Subject: RE: Planning Consultation on EP/48/20/DOC

Engineers Comments Regarding Surface Water Drainage

APPLICATION NO: EP/48/20/DOC

Description of Works: Approval of details reserved by condition imposed under ref EP/121/17/PL relating to Condition Nos 3 - materials & finishes, 4 - hard & soft landscaping, 6 - visibility splays, 7 - car parking spaces, 8 - pedestrian visibility splays, 10 - surface water drainage, 11 - SuDs, 13 - level survey and 15 - Construction Management Plan

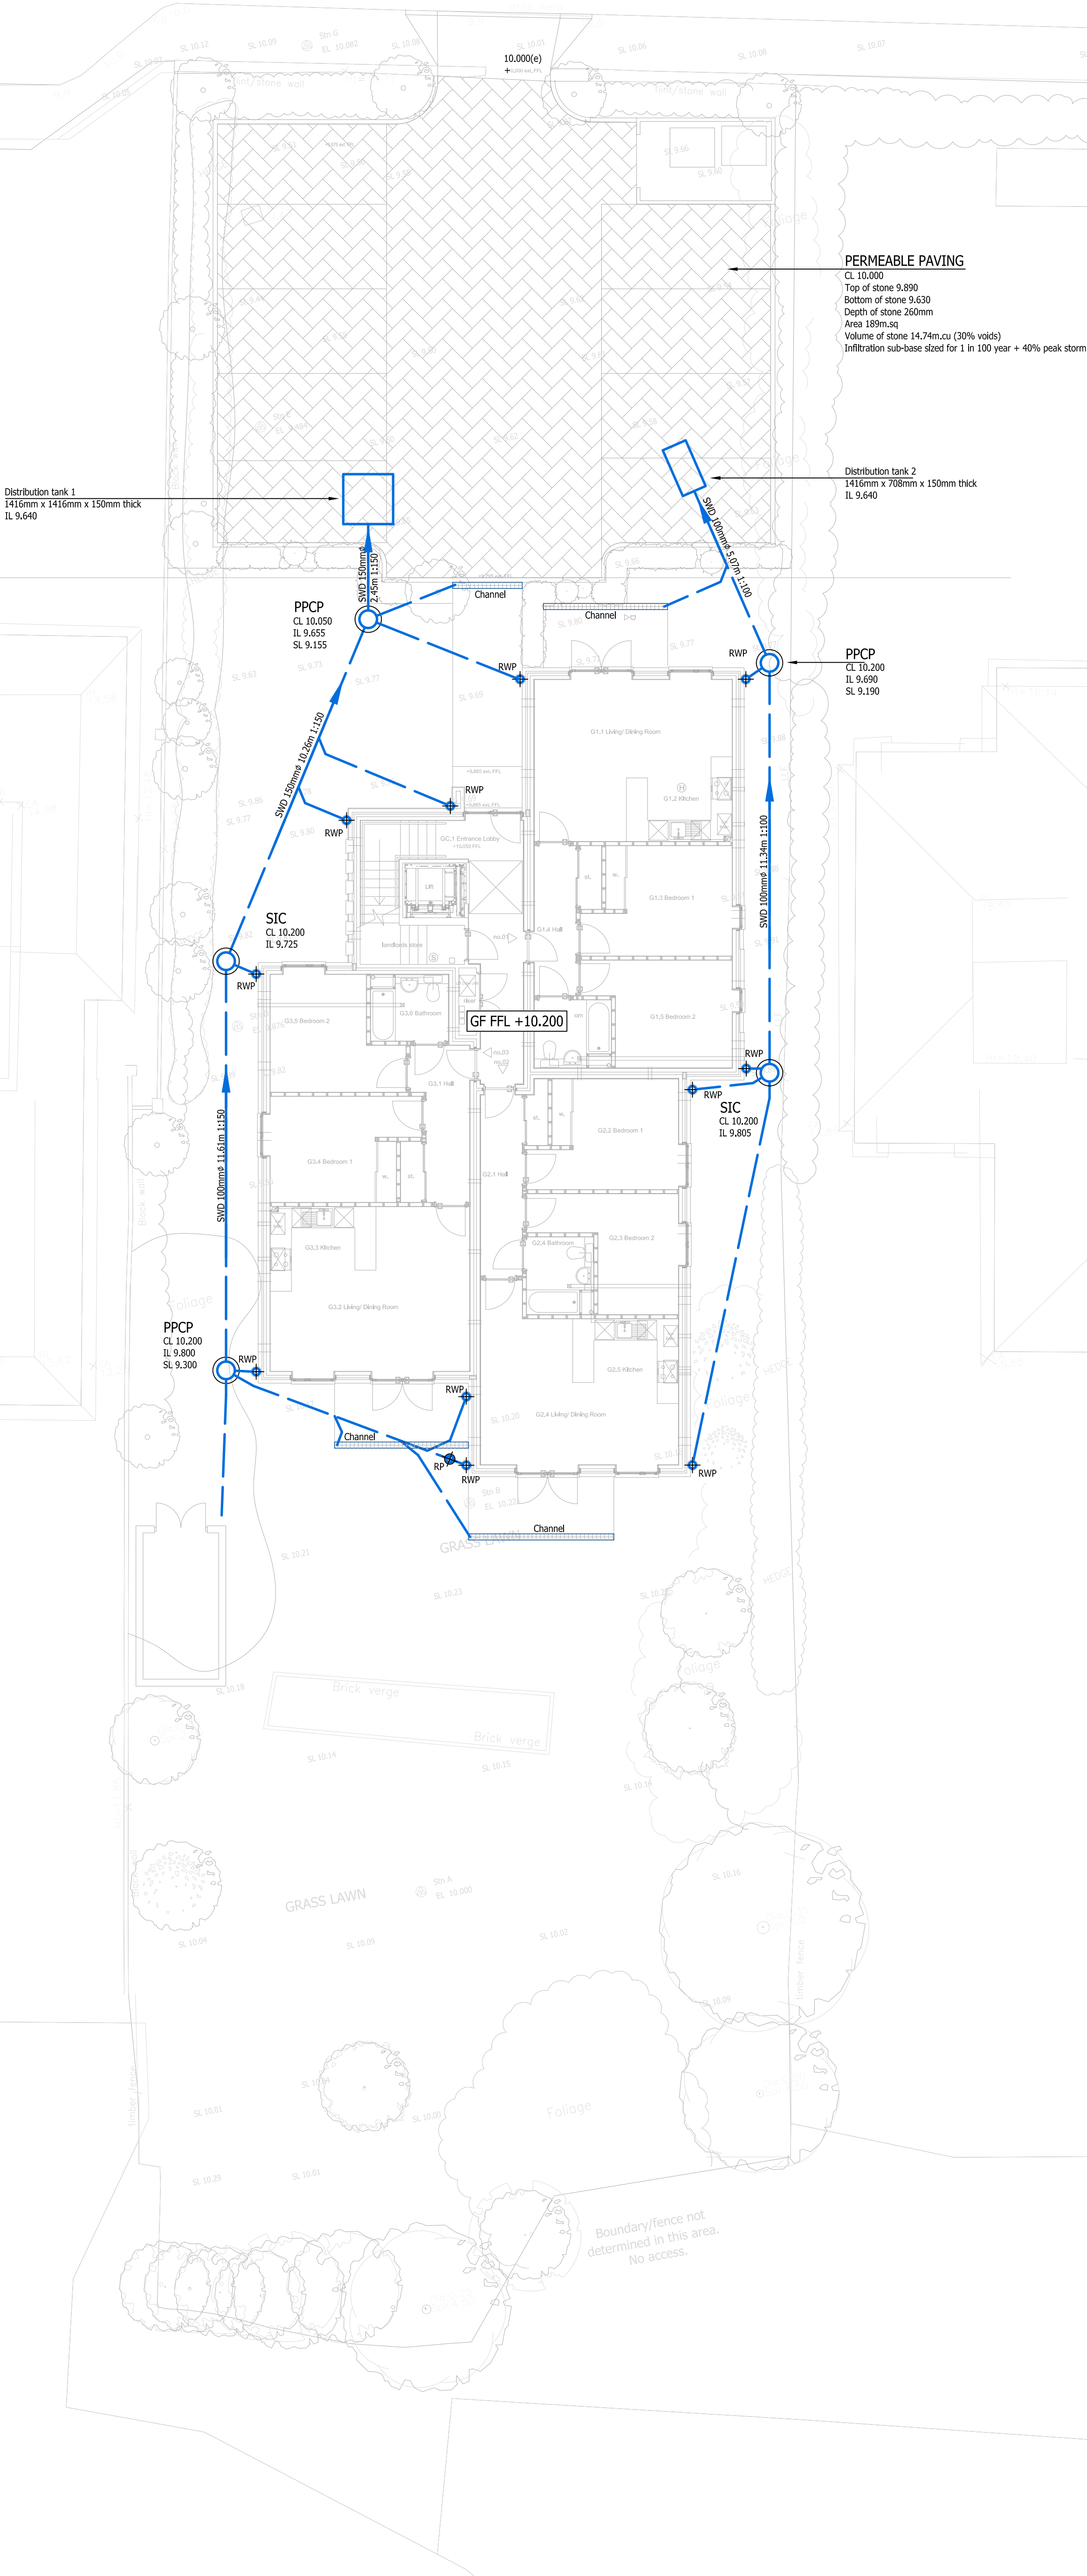
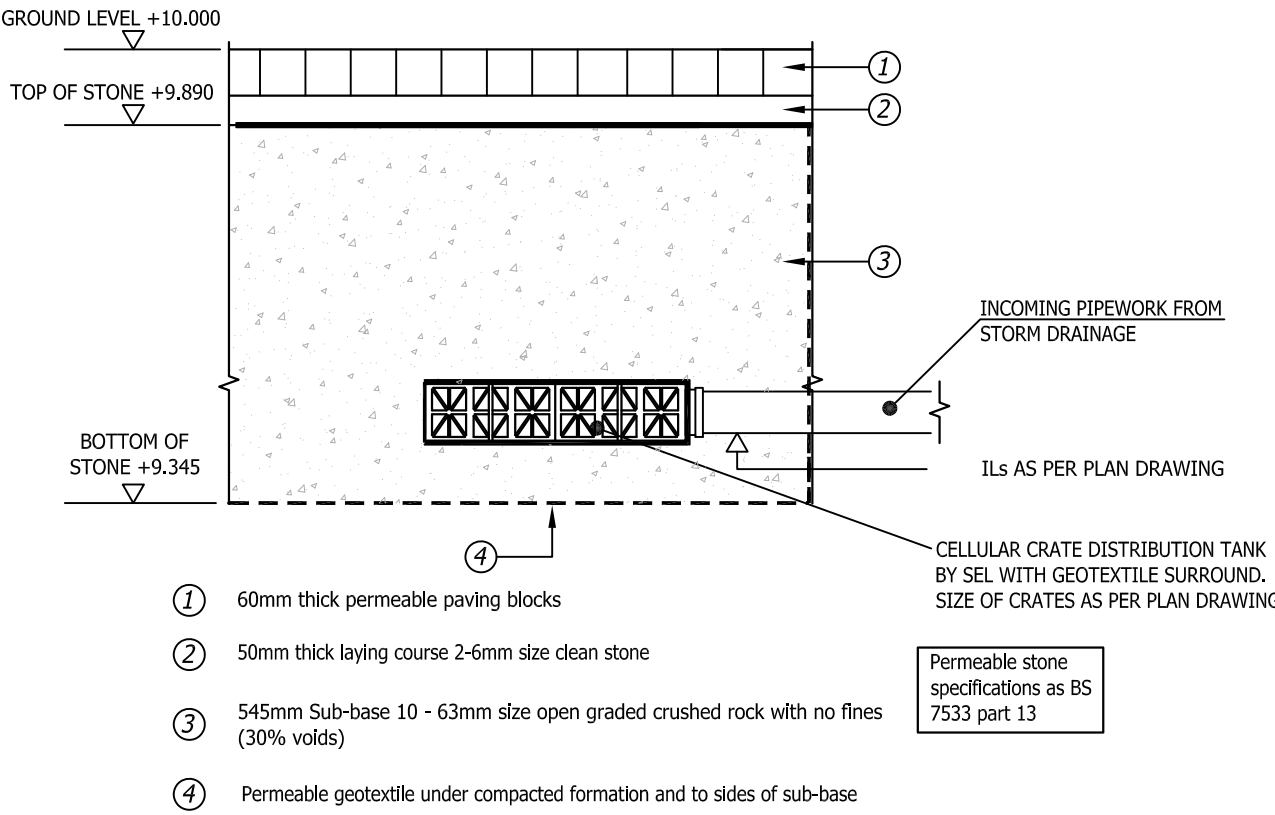
1. The trial pit TP01 is undersized (0.3m x 0.3m rather than 0.3m x 1m specified by BRE365). Please apply a safety factor of 3 to the calculations. Three tests were completed, the date of testing is assumed to be 24/01/2018 (from the test pit stratum record) however this is not clear. Please clarify.
2. Construction detail drawings need to be included for:
 - a. Inspection chambers
 - b. Channel drains
 - c. Pipe bed and surround

Updated plans/construction details (to discharge condition 10) will need to be included.
